Our ref: KT/2024/131819/01-L01
20035862
Your ref: TR020005
Date: 15 July 2024

**Gatwick Airport Northern Runway Development Consent Order Application –
Deadline 7 - Environment Agency comments on further submissions by
Deadline 6**

Figure A. 4: Proposed Drainage Strategy Drawing, indicating EX-CU3, and associated photos
Environmental Statement: June 2024
Appendix 11.9.6: Flood Risk Assessment – Annex 7 Culvert Assessment

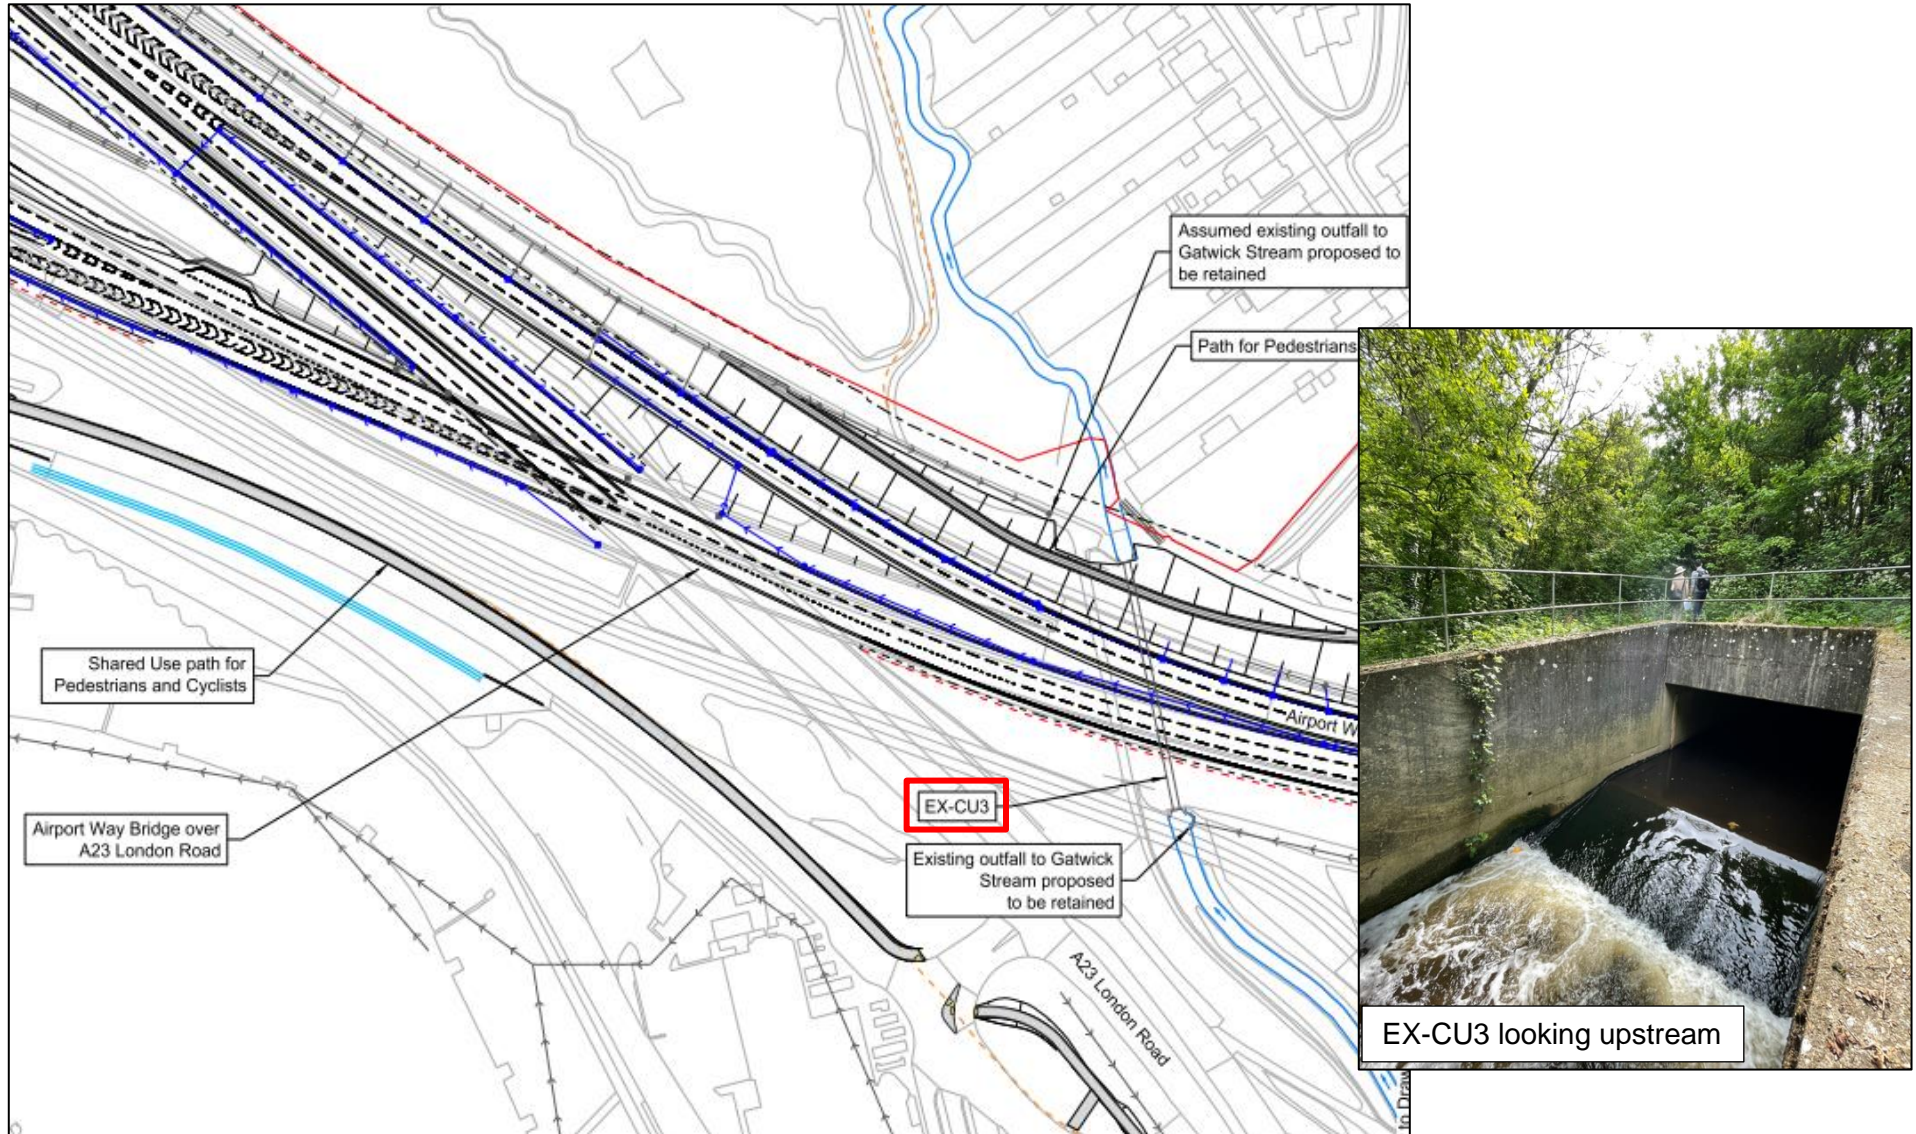
In Annex 7, the nature of any works to EX-CU3 should be clarified. In Table 4.1 it is suggested this culvert is 'existing to be extended' but in Table 2.1 the works are that it remains 'unchanged'.

The blockage assessment set out in Table 4.1 does highlight that all three structures on main river are considered to have a medium blockage risk after following Steps 5 and 6 of the Environment Agency (2019) Blockage Management Guide. This would prompt further work to be carried out to further assess and address the potential blockage risk, as at all three locations, blockage would likely result in flooding to a range of assets. It is noted the applicant states further work will be undertaken at the detailed design stage, though as there is a hydraulic model available that includes structures EX-CU3, LDN-BR and BTN-BR it should be possible to add greater detail around the risks, impacts and mitigation of flood risk associated with these works.

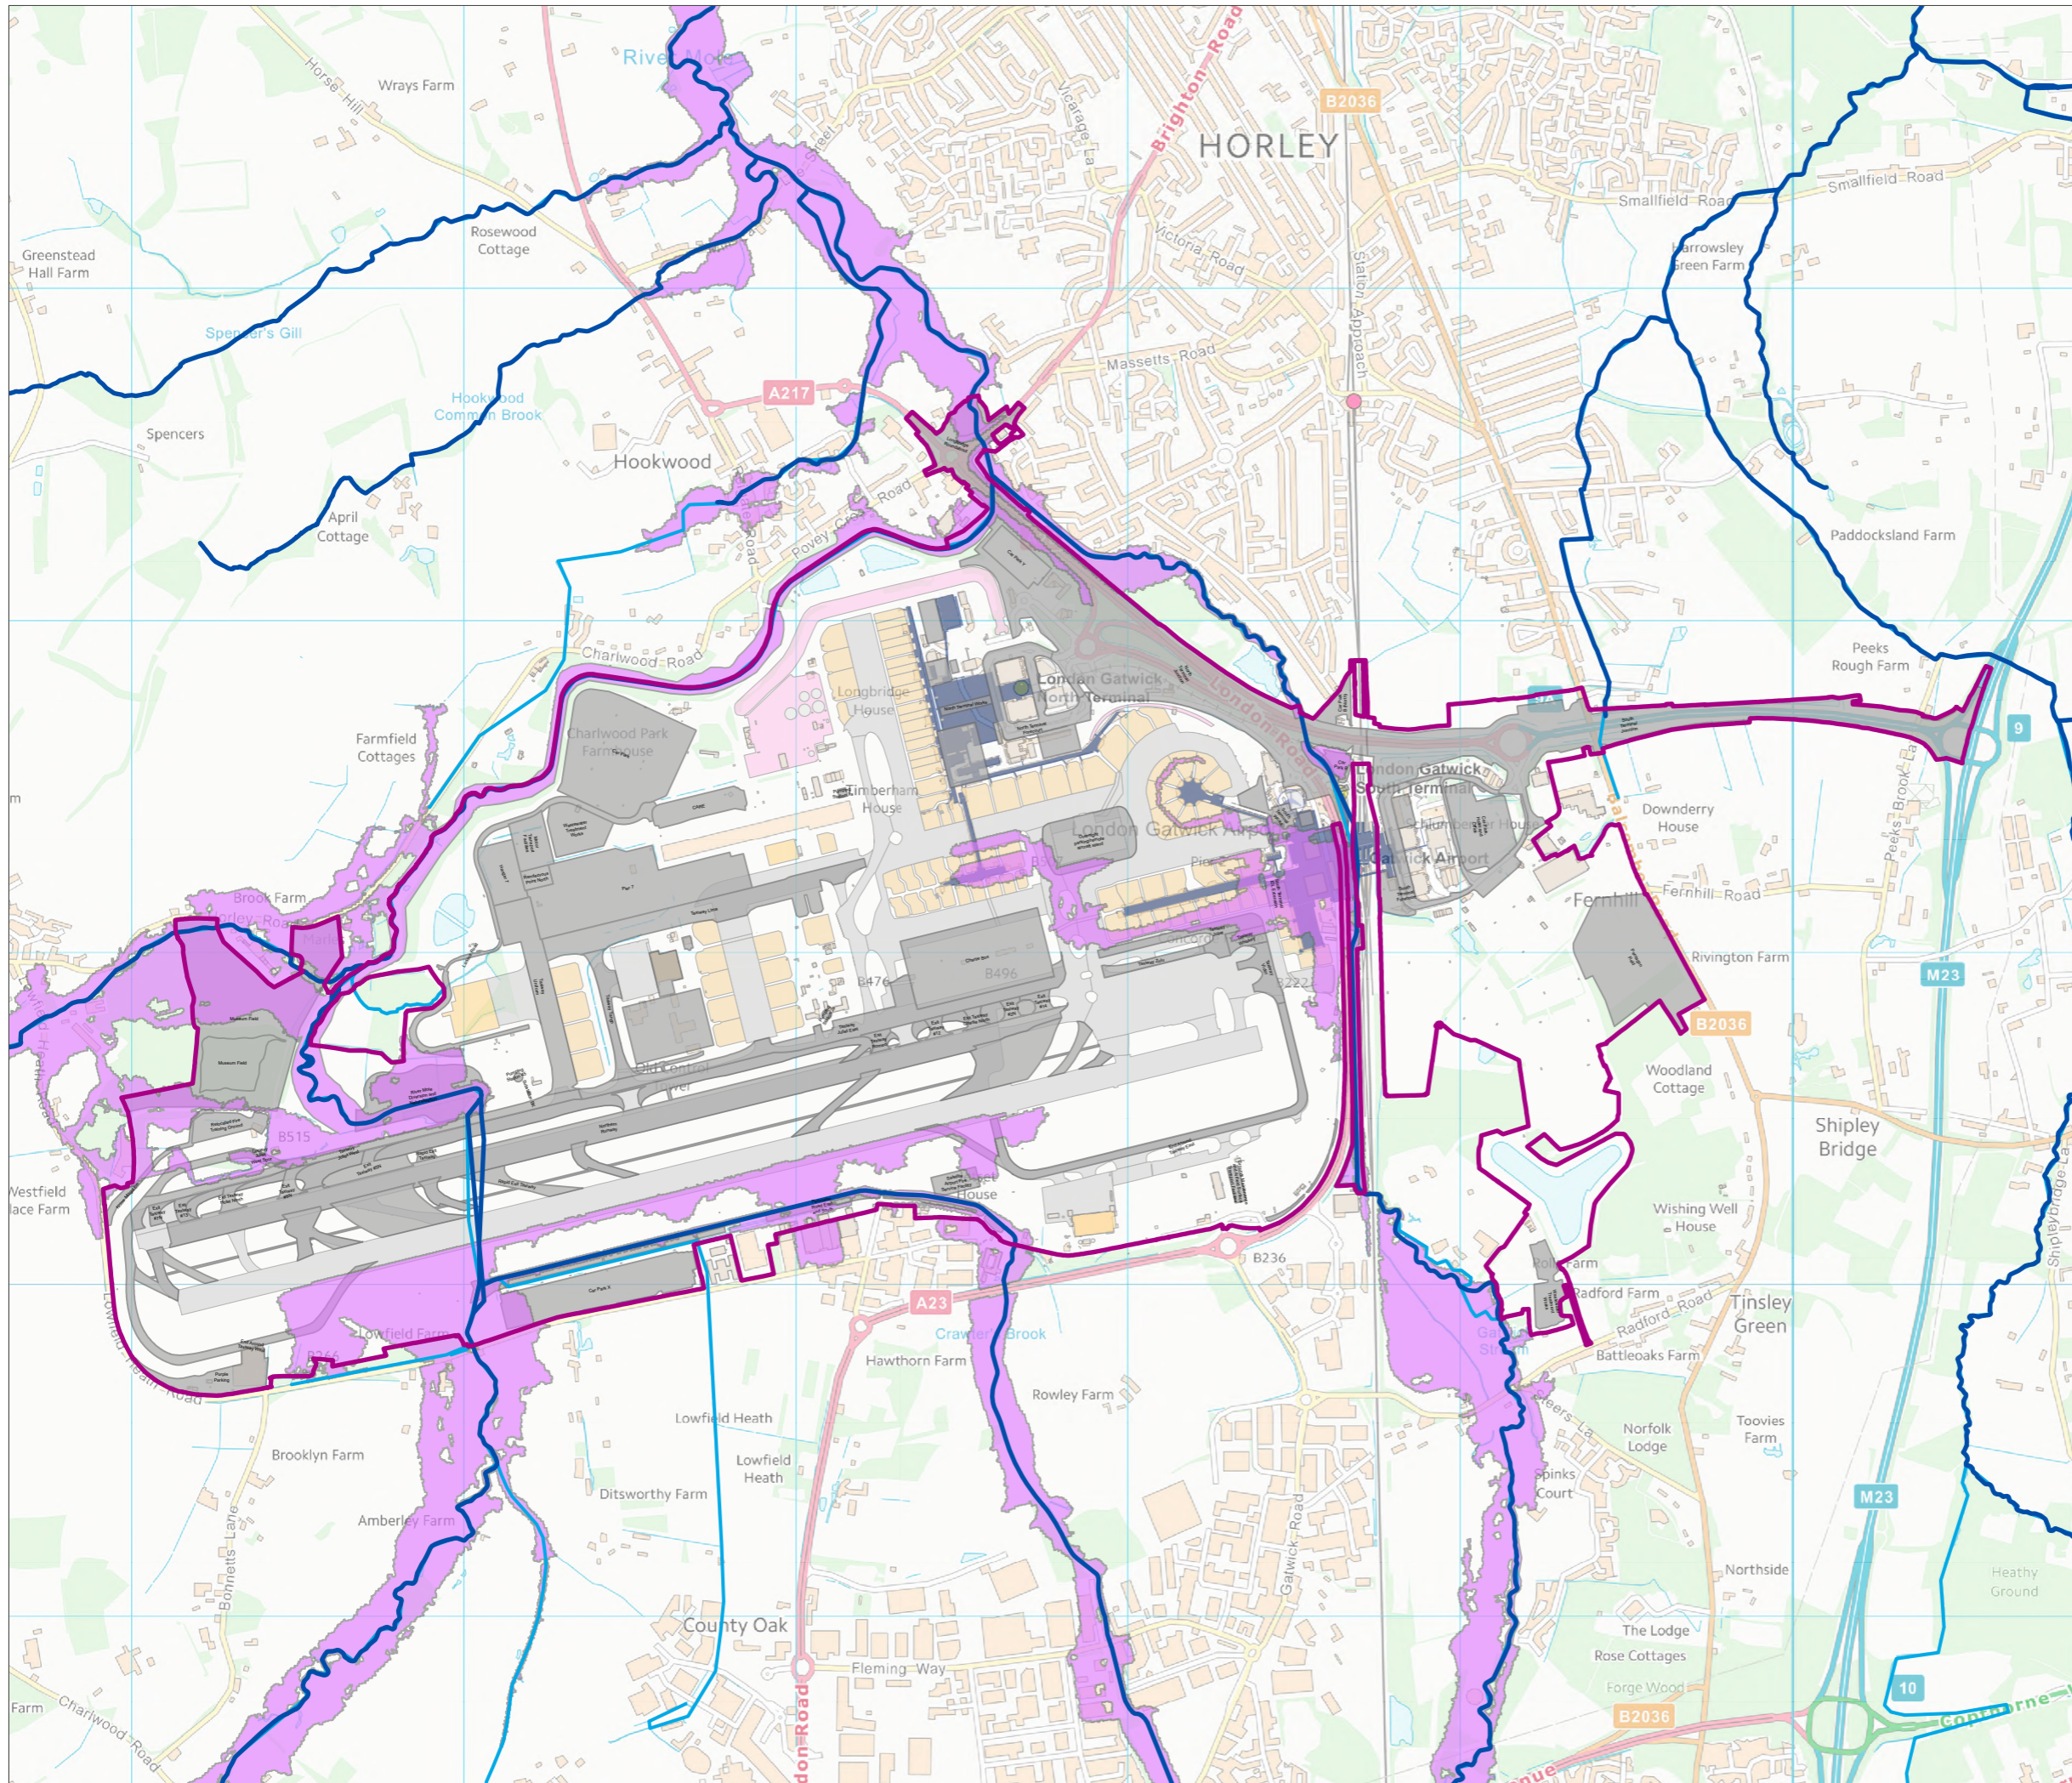
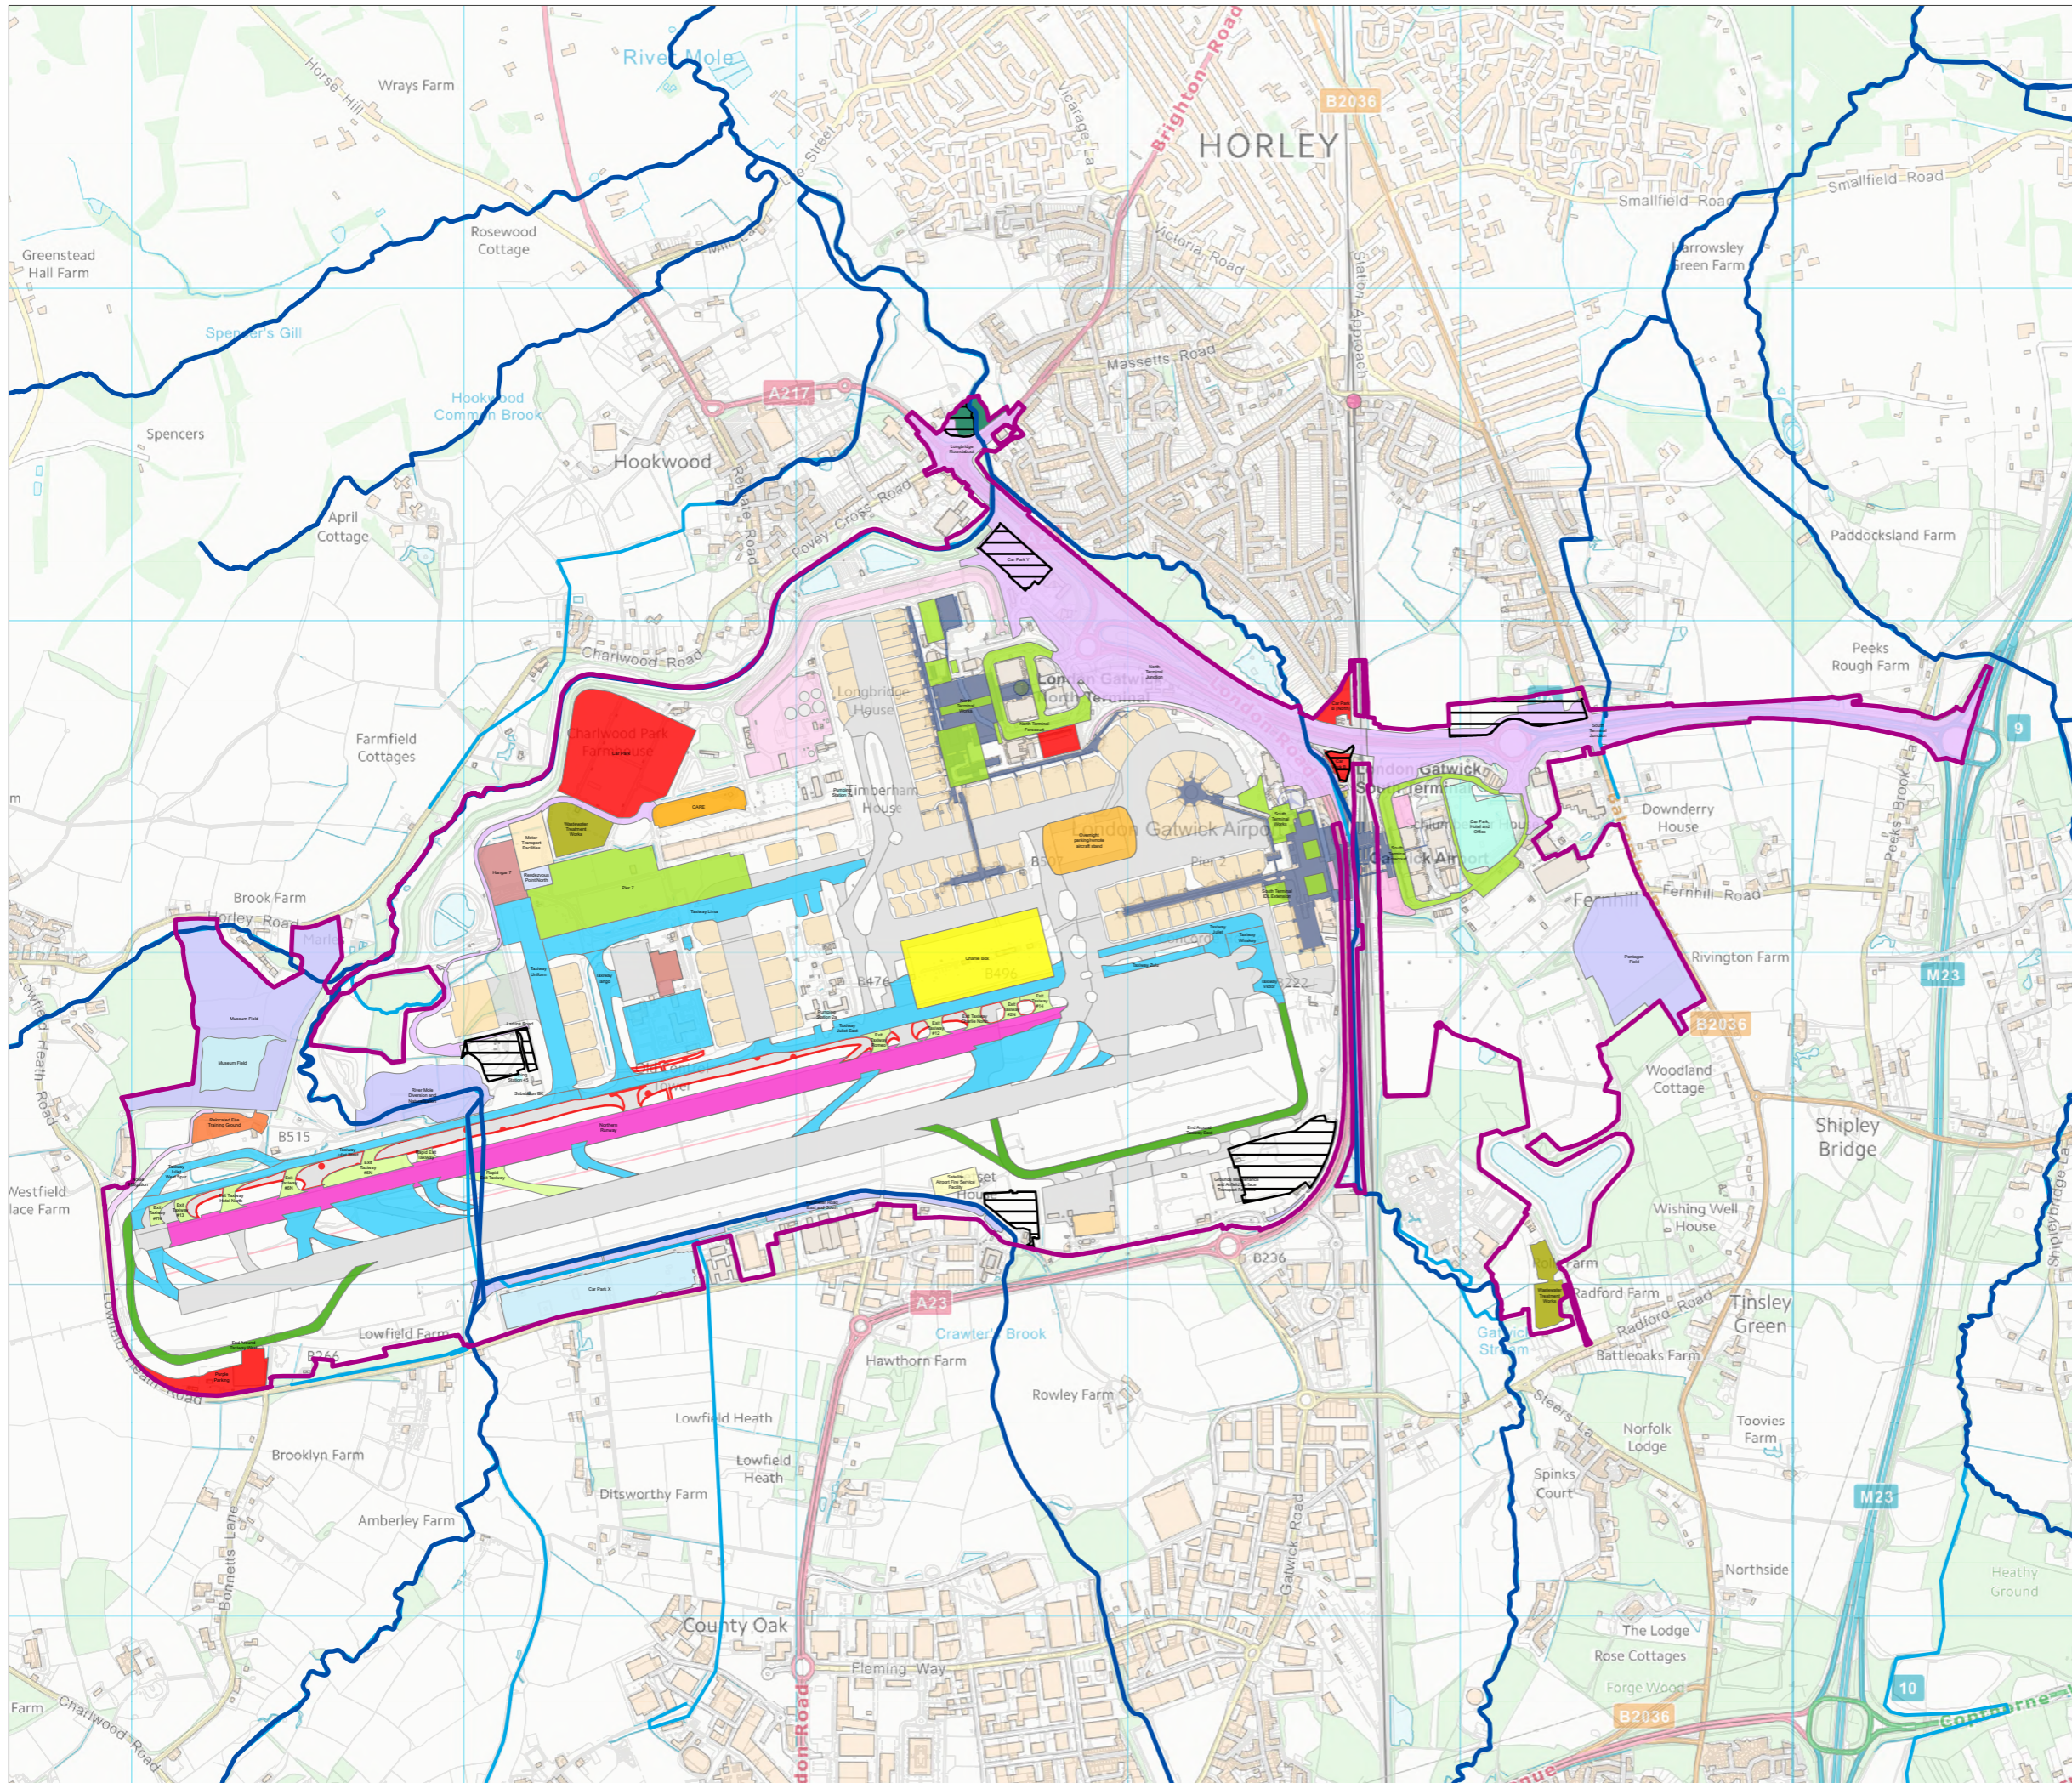
Table 5.1 is helpful in setting out the Work Nos, whether they are in the floodplain and whether it is considered mitigation needs to be provided prior to their construction. Two Figures are also included, 1.1 and 1.2, which are also helpful in depicting the extent of the 1 in 100-year + 16% modelled floodplain extent and the location of various works. If Table 5.1 could be colour coded depending on the category of the works (in/out of floodplain, mitigation measure, mitigation required or not) it would help to make this Table easier to understand. In addition, if this colour coding could also be used on an additional map that showed the various works with their associated Work Nos as set out in the draft DCO and used within the FCDP Technical Note, it would again make the FCDP easier to understand.
